# CITY OF ALBUQUERQUE

February 13, 2025

**RE: 1306 Broadway Blvd SE  
Conceptual Grading & Drainage Plan  
Engineer's Stamp Date: 1/8/2025  
Hydrology File: L14D068  
Case # HYDR-2025-00002**

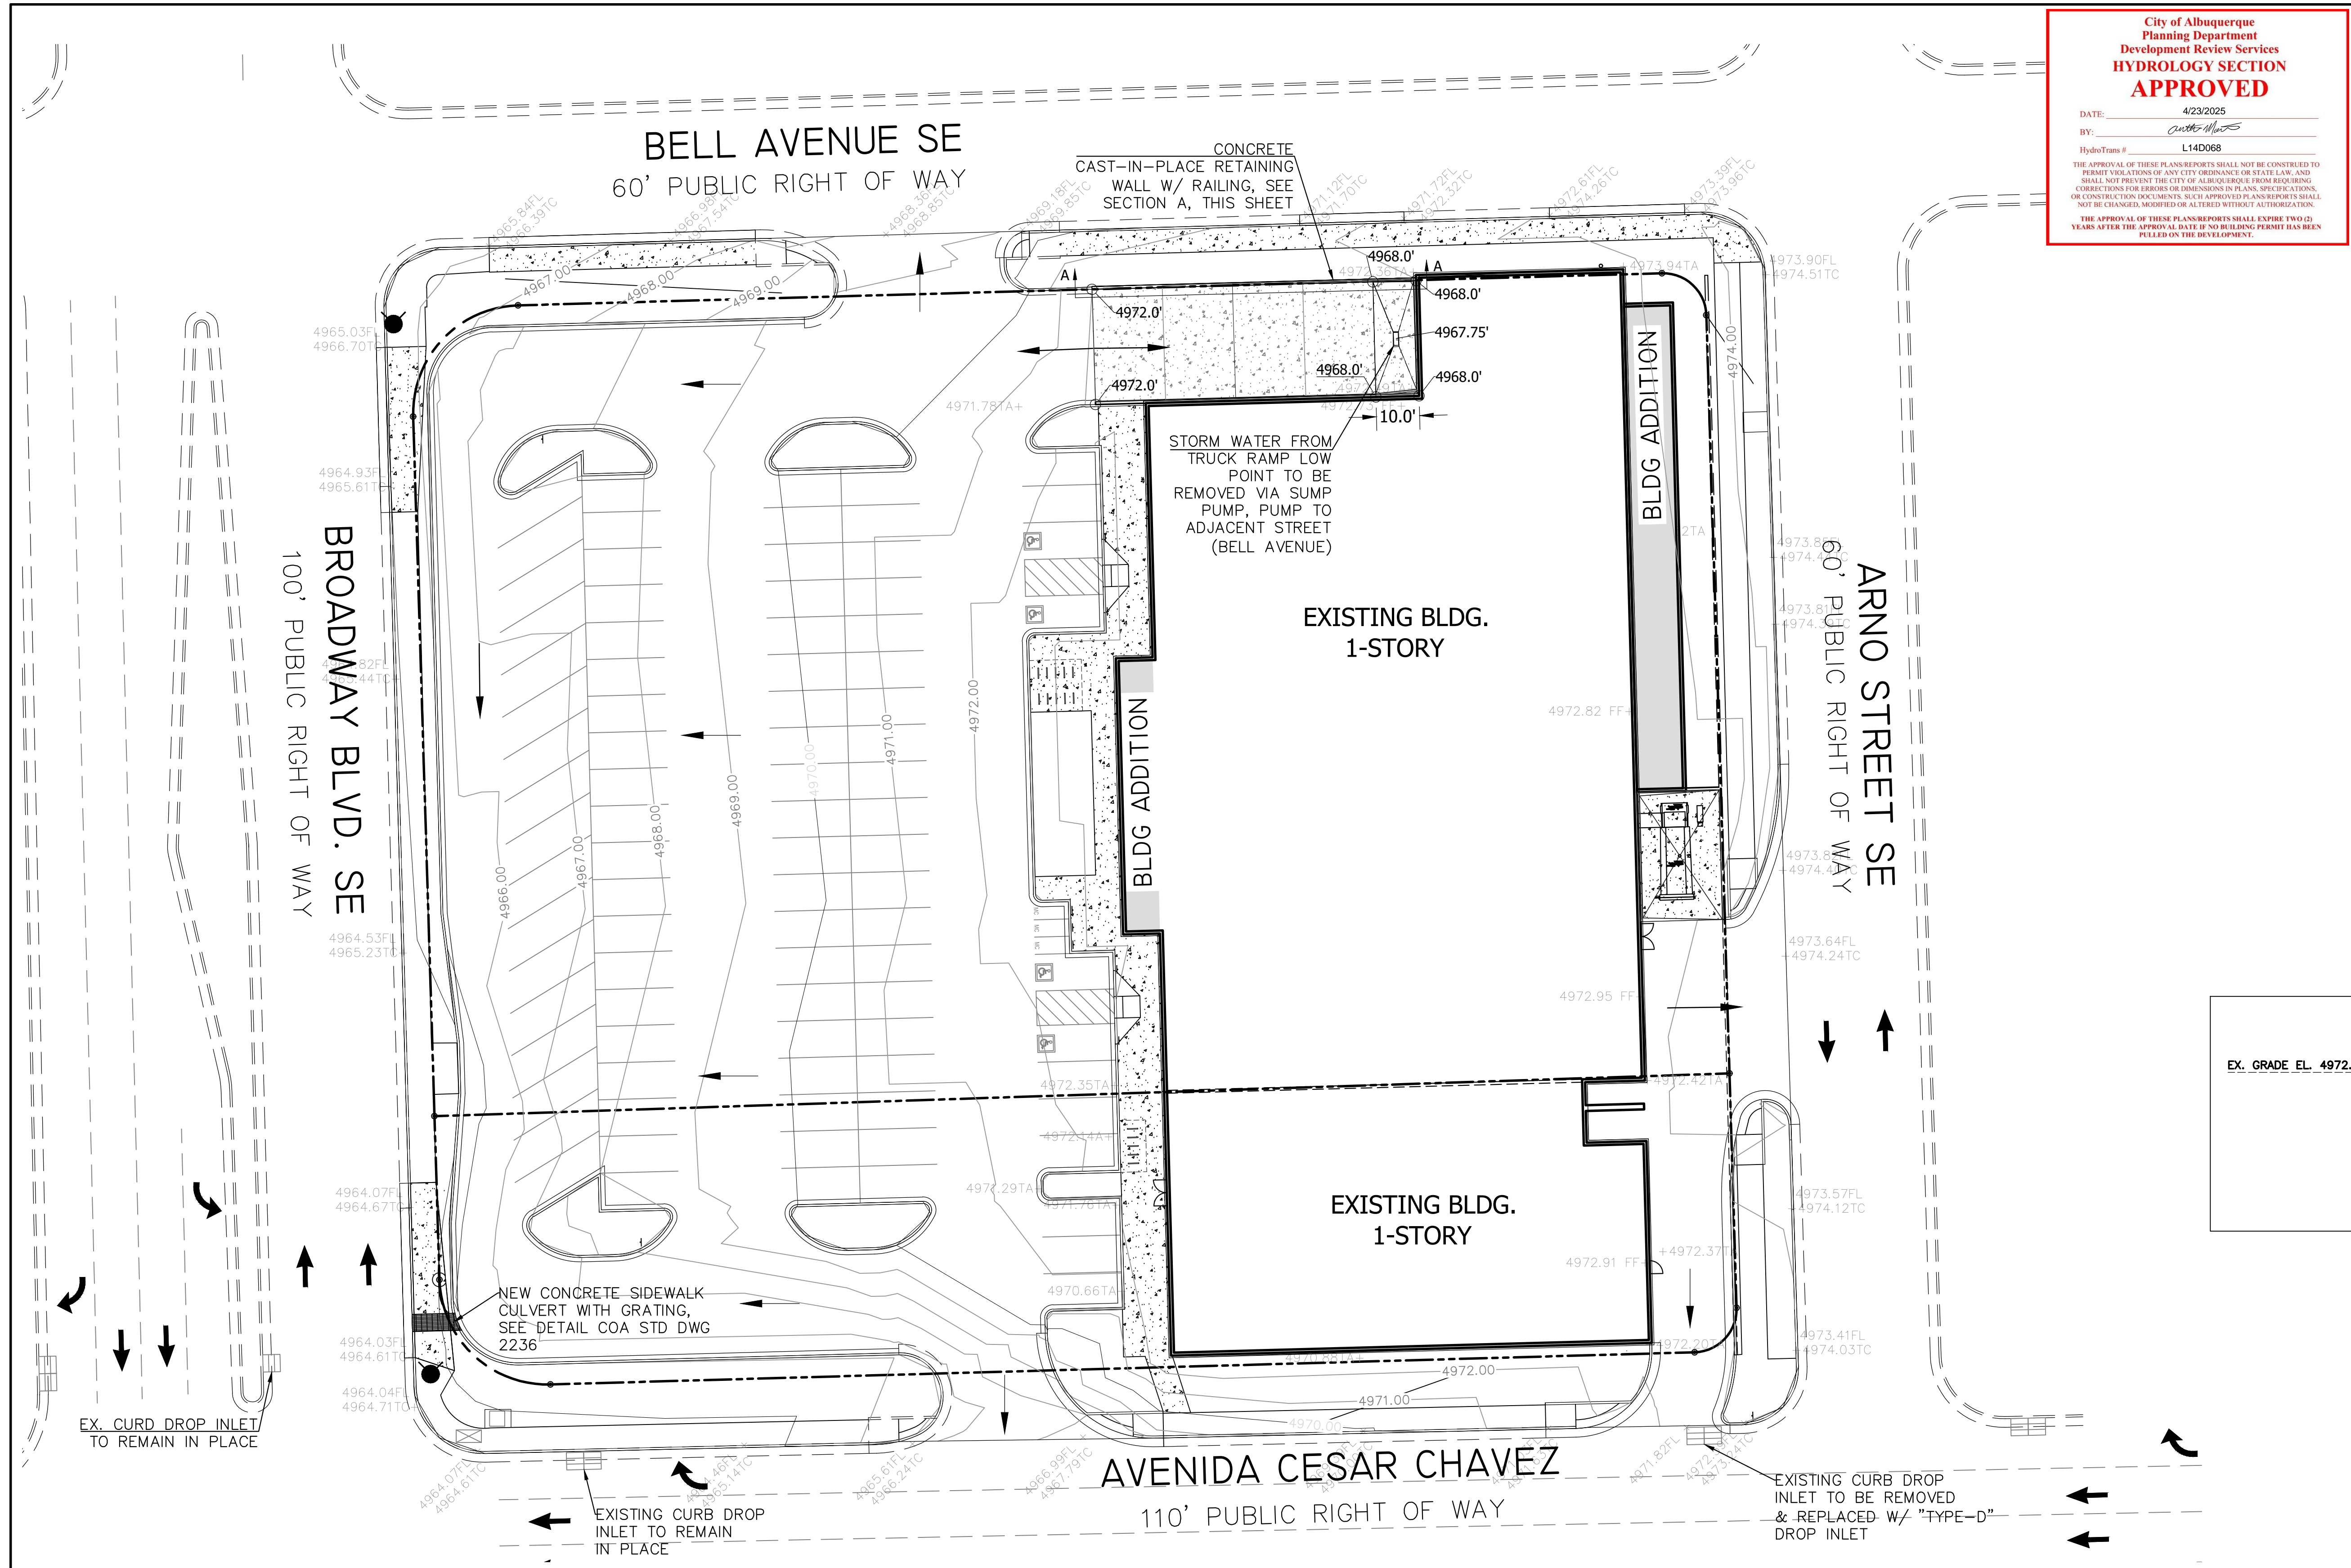
1. Please submit a more detailed Grading & Drainage Plan to Hydrology for review and approval.

2. If requesting a Waiver of Management Onsite, the following conditions of the new drainage ordinance (enacted 10/2/18) must be demonstrated on the plan (§ 14-5-2-6 (H)):

Show where stormwater quality can be effectively controlled through private offsite mitigation, or through an arrangement to utilize a cooperator's existing regional stormwater management infrastructure or facilities that are available to control stormwater quality.

And where one (or more) of the following is met:

- the lot is too small to accommodate management on site while also accommodating the full plan of development;
- the soil is not stable;
- the site use is inconsistent with the capture and reuse of stormwater;
- other physical conditions exist where compliance with on-site stormwater quality control requirement leaves insufficient area;

- public or private off-site facilities provide an opportunity to effectively accomplish the mitigation requirements of this ordinance;
  - there is an opportunity to develop a project to replenish regional ground water supplies at an offsite location; or
  - a waiver to state water law or acquisition of water rights would be required in order to implement management on site.
3. If requesting a Waiver of Management Onsite, please add a note which states, "The Owner has elected to pay the Payment in Lieu for the required Stormwater Quality Volume."
  4. If requesting a Waiver of Management Onsite, please show the Payment calculation on the plan.
